## **RESPONSE TO SUBMISSIONS: PROPOSED INDUSTRIAL FOOD MANUFACTURING FACILITY**

2 AND 14 DISTRIBUTION DRIVE, ORCHARD HILLS  
LOT 10 AND 11 DP 271141

Prepared by Willowtree Planning Pty Ltd  
on behalf of Snack Brands Australia

**3 February 2022**

Drawing Title:
Landscape Plan
DWG No:

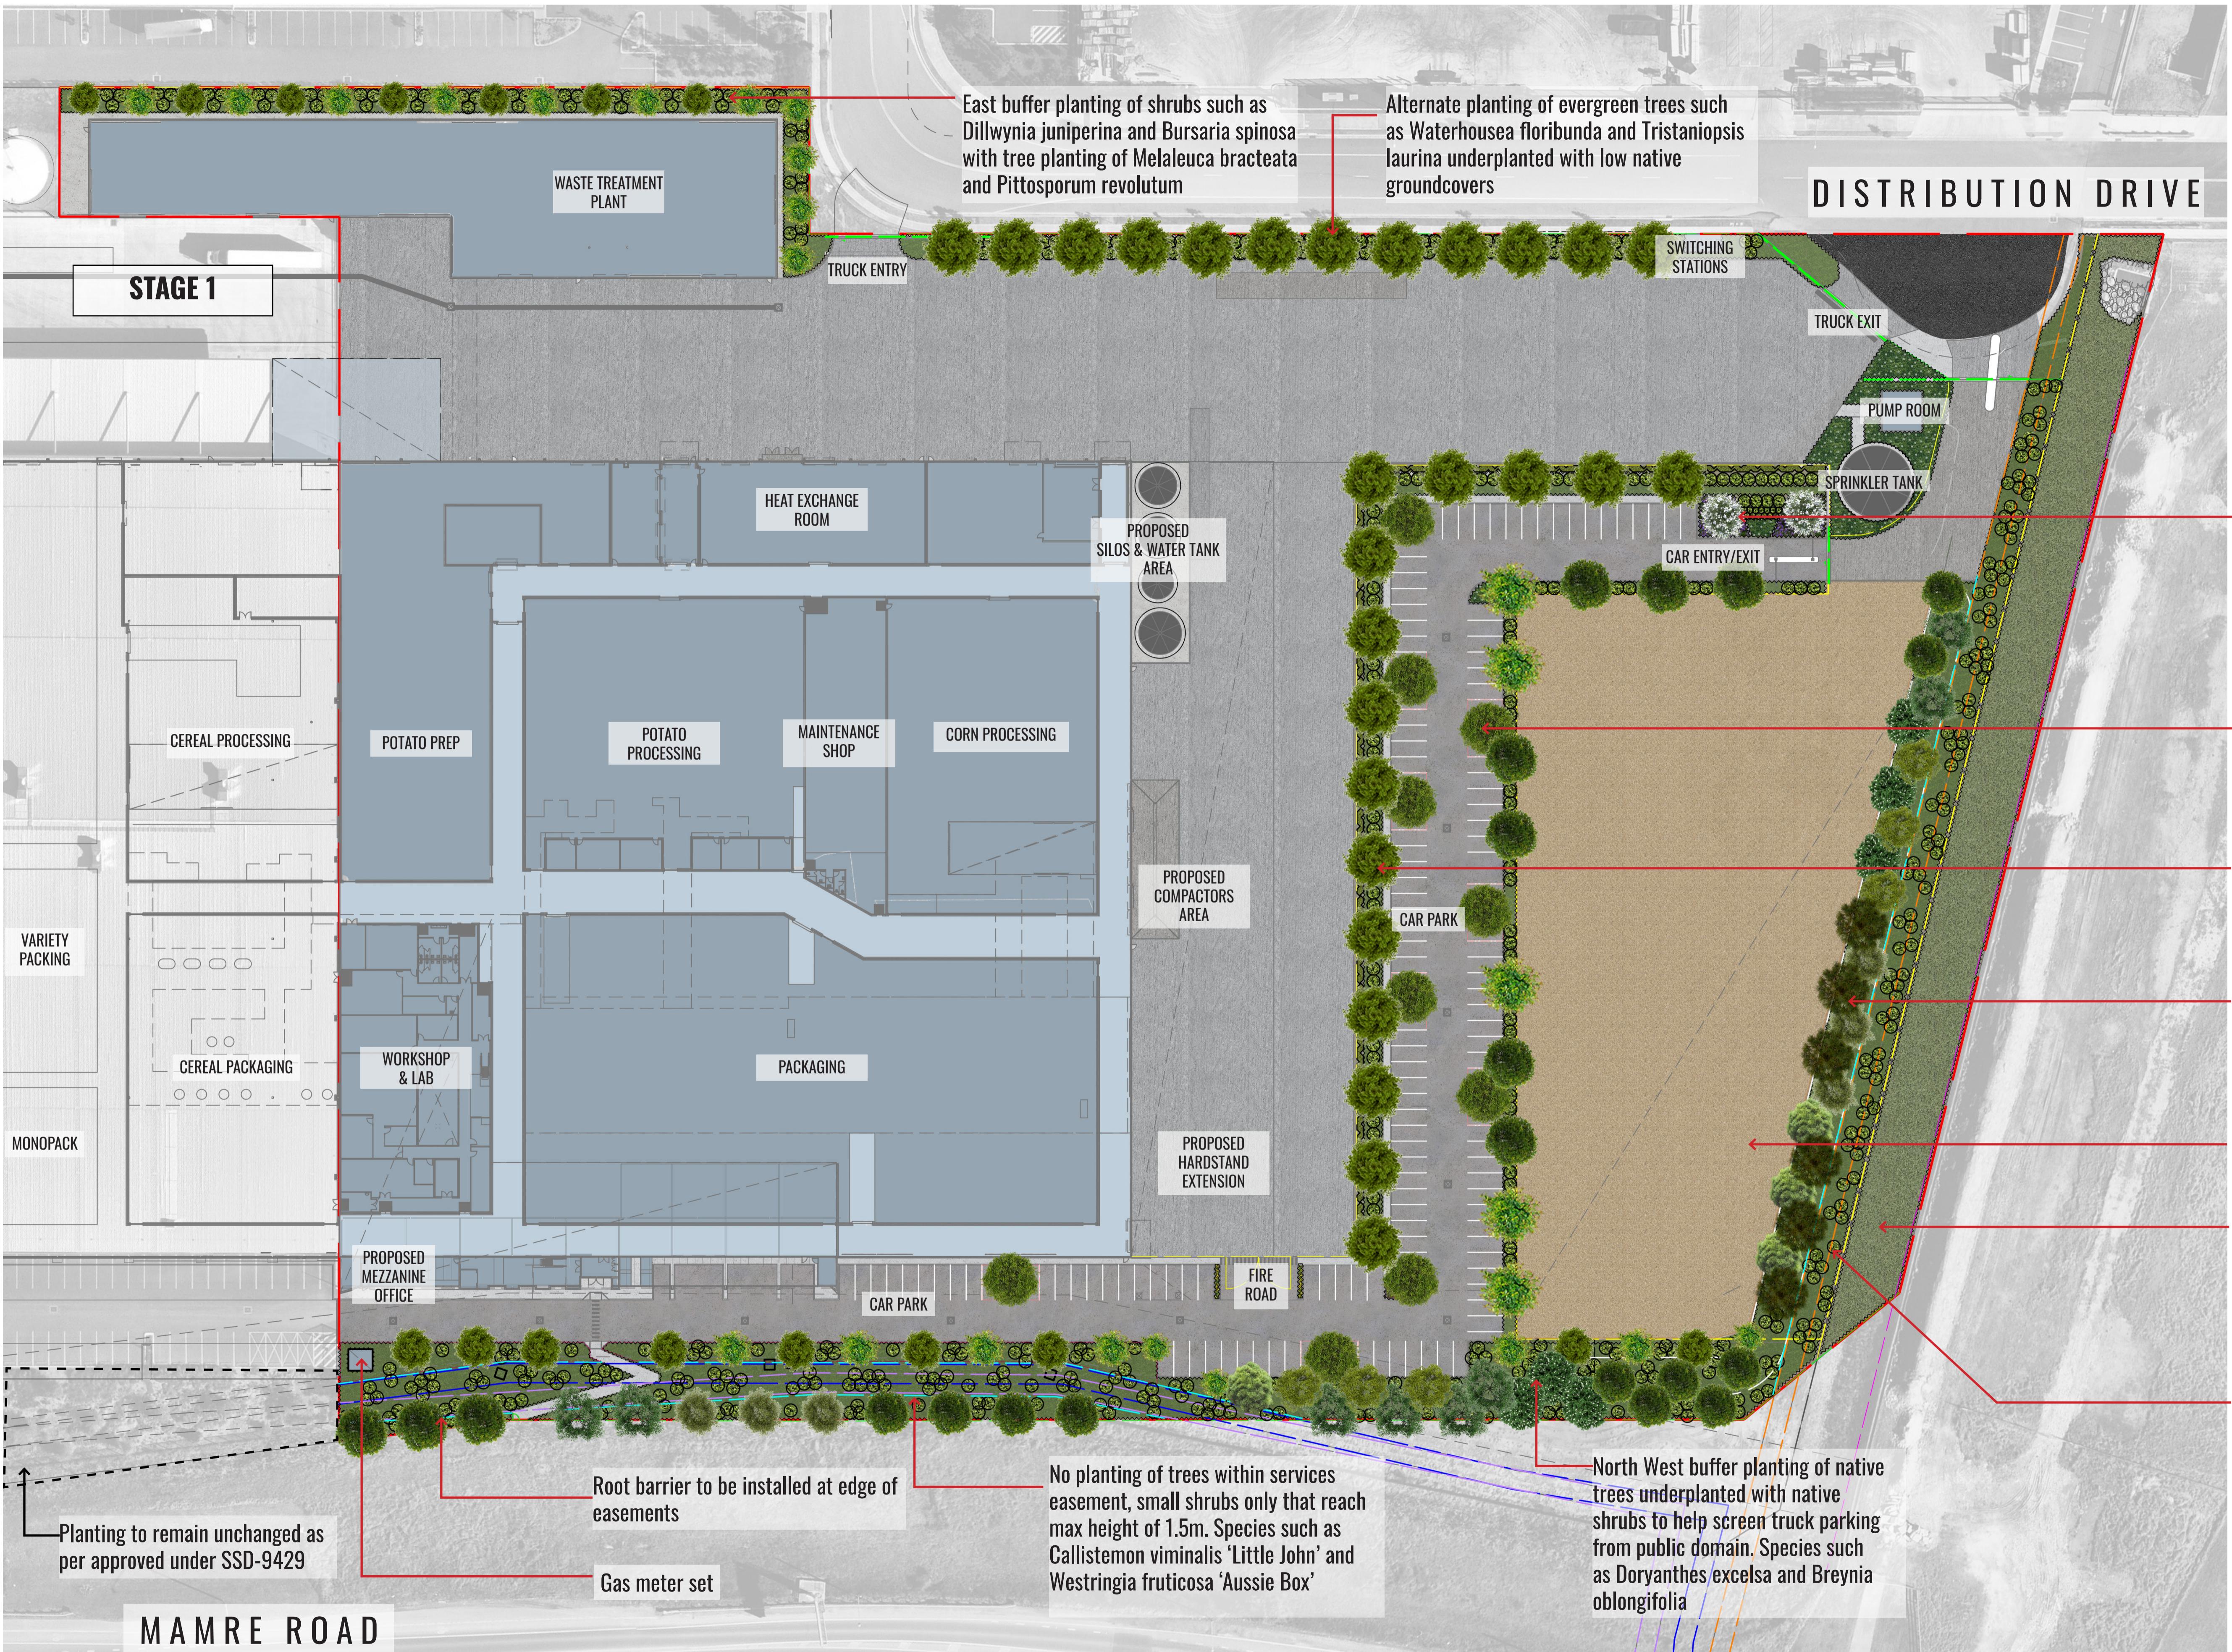
| SUBMITTER | MATTERS RAISED | COMMENTS / REQUESTS  | FORMAL RESPONSE  |
|-----------|----------------|--|--|
|           | Residual Land  | The northern boundary of the site is proposed to remain undeveloped as residual land for use as temporary truck parking and the EIS stipulates the residual land is not included as part of this SSD application. However, this contradicts the Architectural Plans and Landscape Plans which indicate the residual land will be used as an erosion and sediment control basin during construction and layered with compacted aggregate to engineering standards to sustain truck parking. Please confirm whether development consent is sought for works within and use of the residual land for heavy vehicle parking. | It is confirmed that the northern residual land would be used as an erosion and sediment control basin during construction and layered with compacted aggregate (to engineering standards) to sustain truck parking, on a temporary basis.<br><br>This RTS Report has been updated to reflect these comments, as provided in <b>Section 4.1</b> .  |

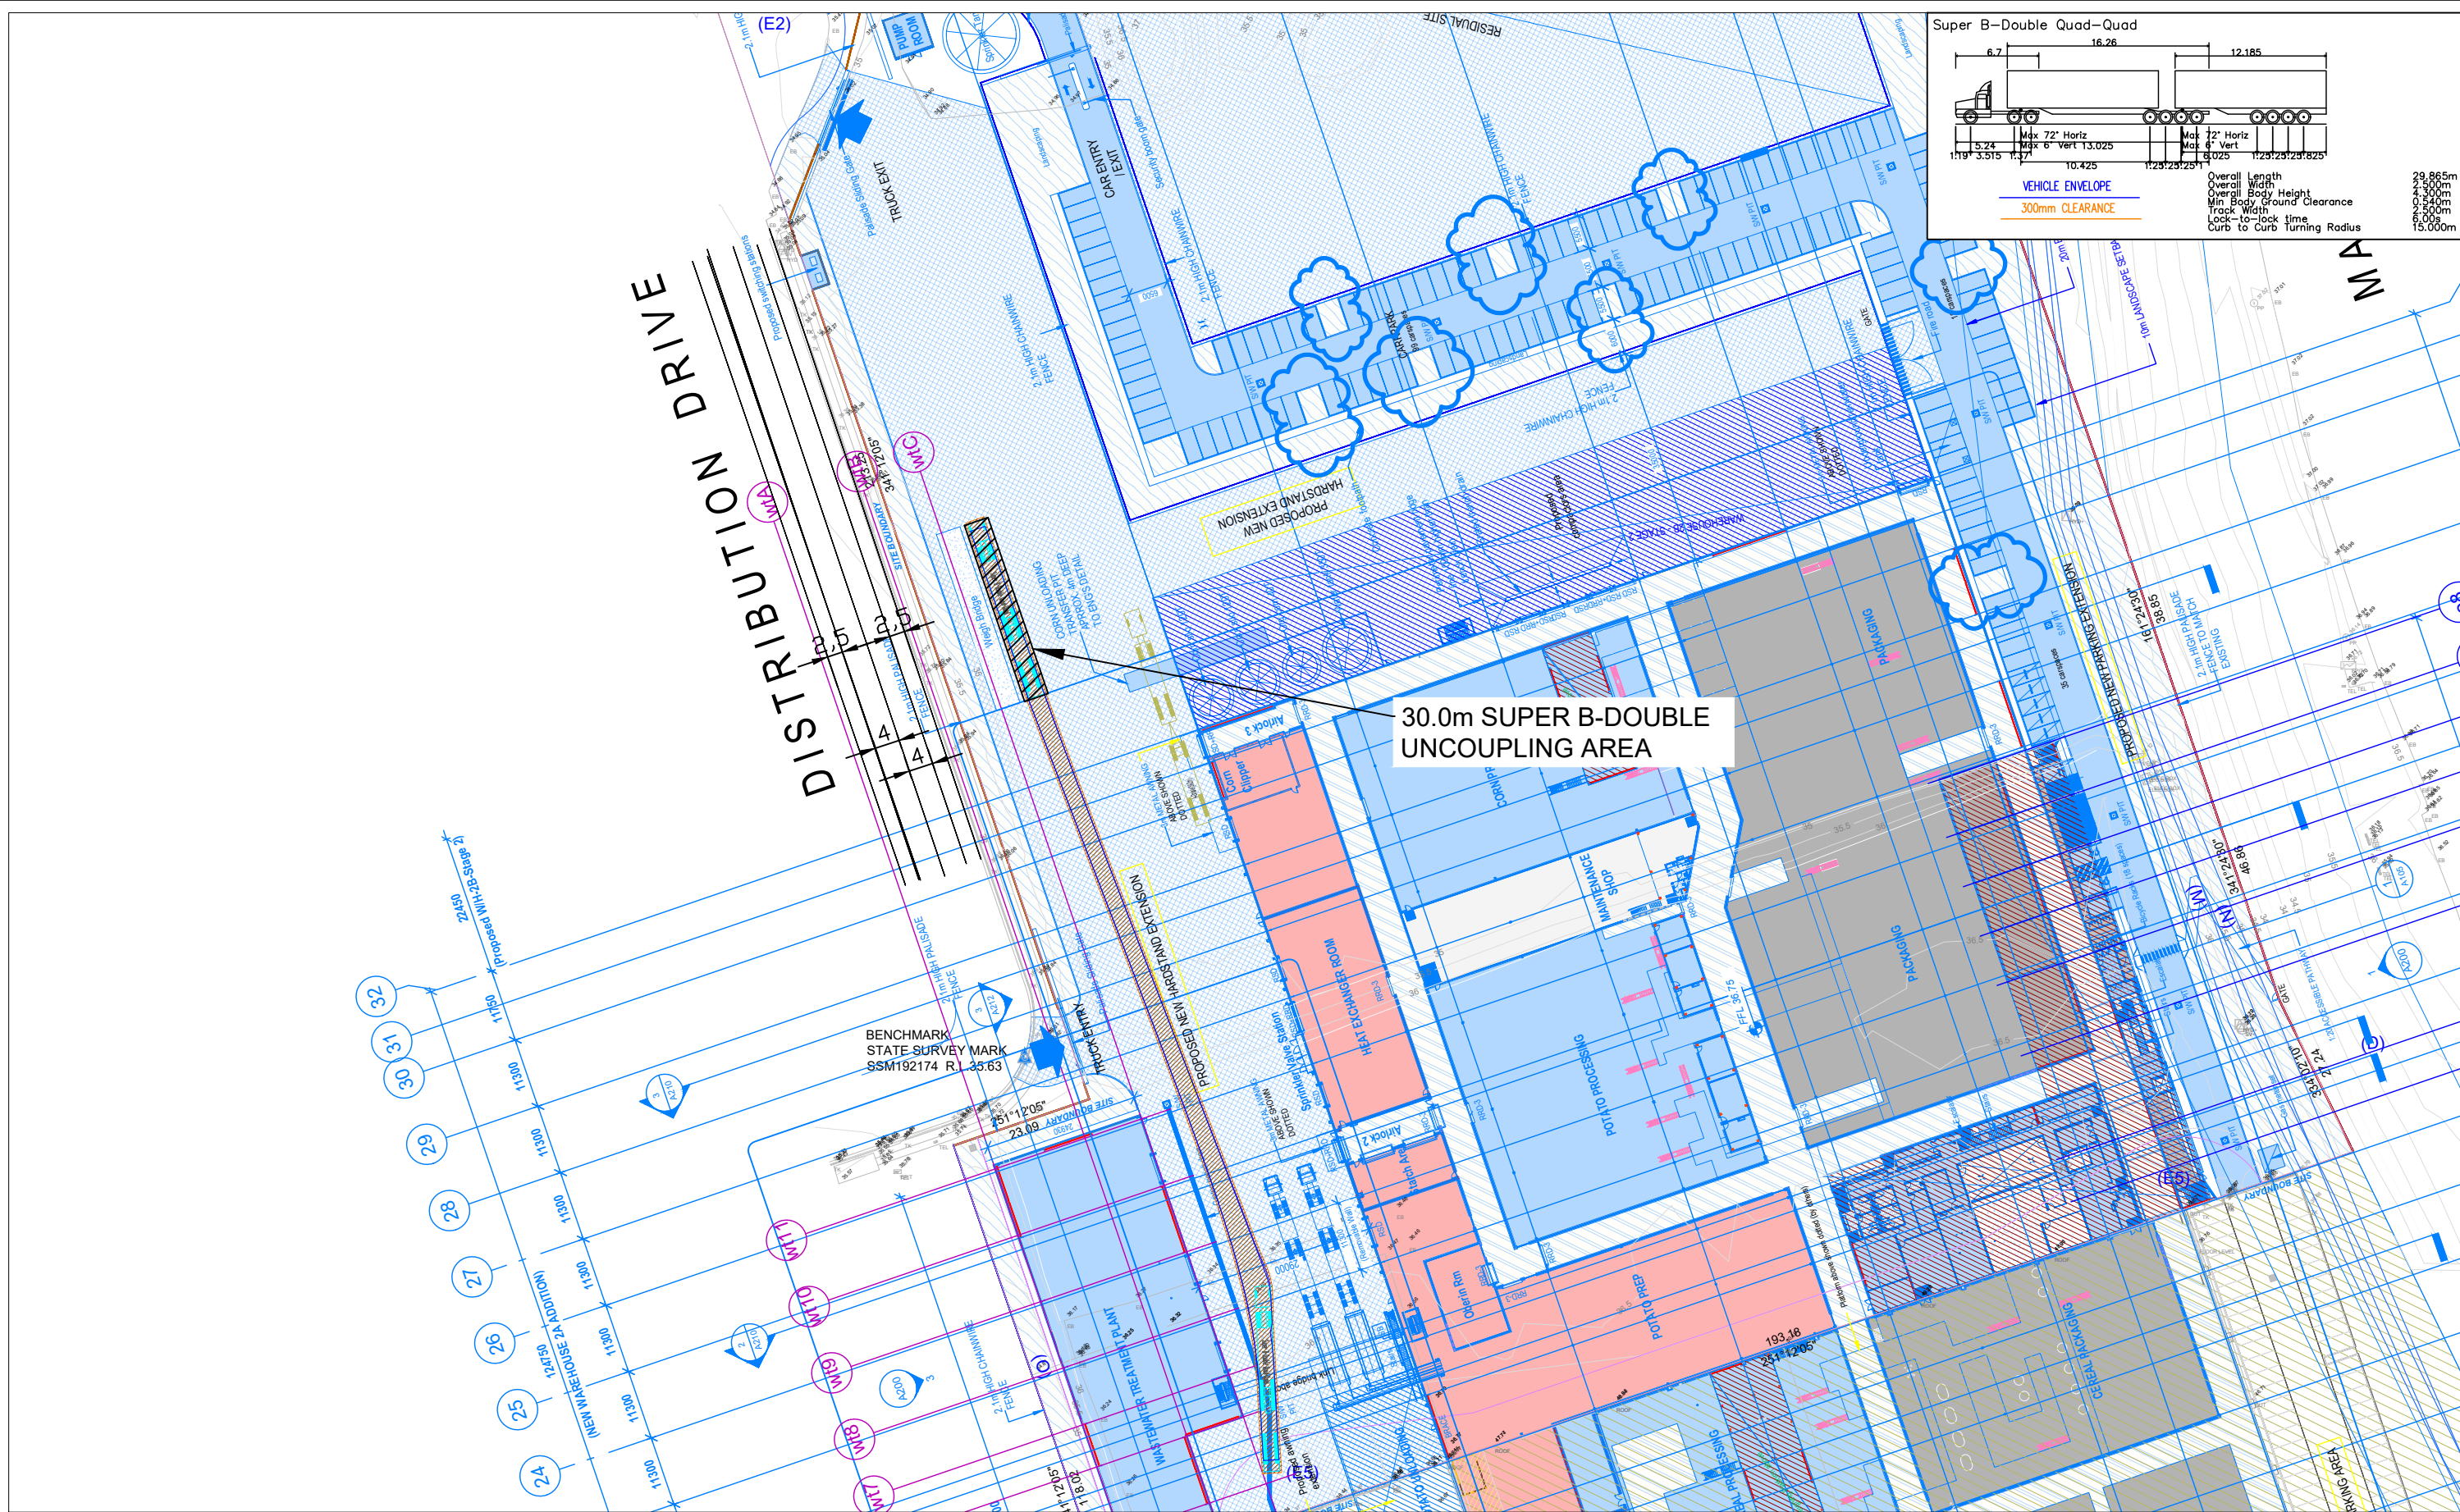
| SUBMITTER | MATTERS RAISED                     | COMMENTS / REQUESTS  | FORMAL RESPONSE   |
|-----------|------------------------------------|--|---|
|           | Site Access and Manoeuvrability    | As mentioned above, the Department notes the development operations will include the delivery of products and materials such as oils and flours to the manufacturing facility.<br><br>However, the SWEPT path analysis drawings provided only demonstrate the vehicle movements of raw potato and corn material delivery to the site. The Department requests further SWEPT path analysis demonstrating the movements of all delivery vehicles to the site including the identification of distribution/delivery points on the site. | All swept path analysis – per SBA instructions – have been included in the Transport Assessment, dated 20 August 2021 (Appendix 17 of the EIS).<br><br>Furthermore, in response to the TfNSW request, Ason Group have conducted super B-Double swept paths, which are appended to their Traffic Statement contained with <b>Appendix C4</b> of this RTS Report.   |
